Our Ref: Y/53/19/NMA

Non-material amendment following the grant of reference Y/60/16/PL for change of material to proposed extension and set north elevation fenestration & doors behind existing timber posts.

North Open Barn Hoe Lane Flansham Yapton PO00 8NT

East Elevation

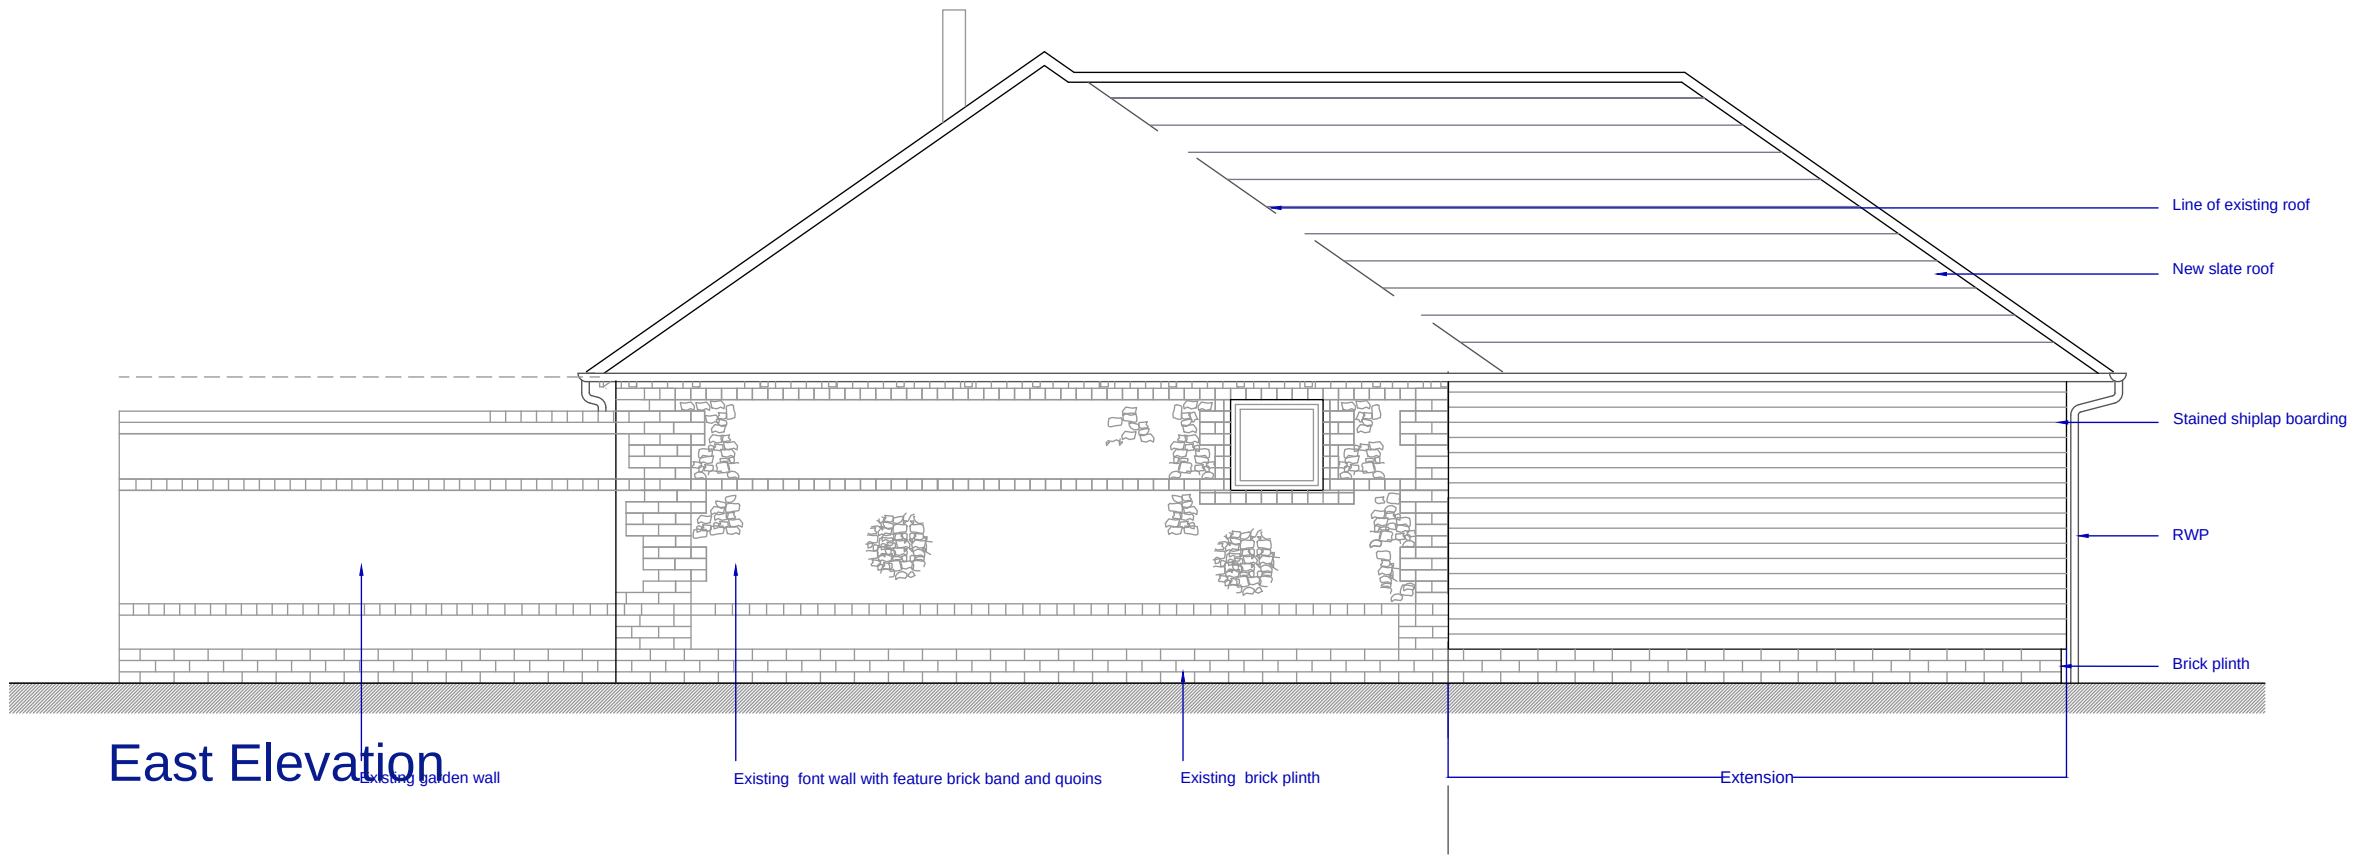
- (a) Changing the material to the proposed extension from flint with brick banding & quoin corners to dark stained timber ship boarding; and
- (b) Set the north elevation fenestration and doors behind the existing timber posts.

Please note that the drawings 13-1 Rev A "Amended Elevation North"; 14-1 "Amended Elevation East"; 16-1 "Amended Elevation West"; and 17-1 Rev A "Amended ground floor plan" replace drawings 13 Rev B "Front (North) elevation proposed"; 14 Rev B "Side (East) elevation proposed"; 16 Rev A
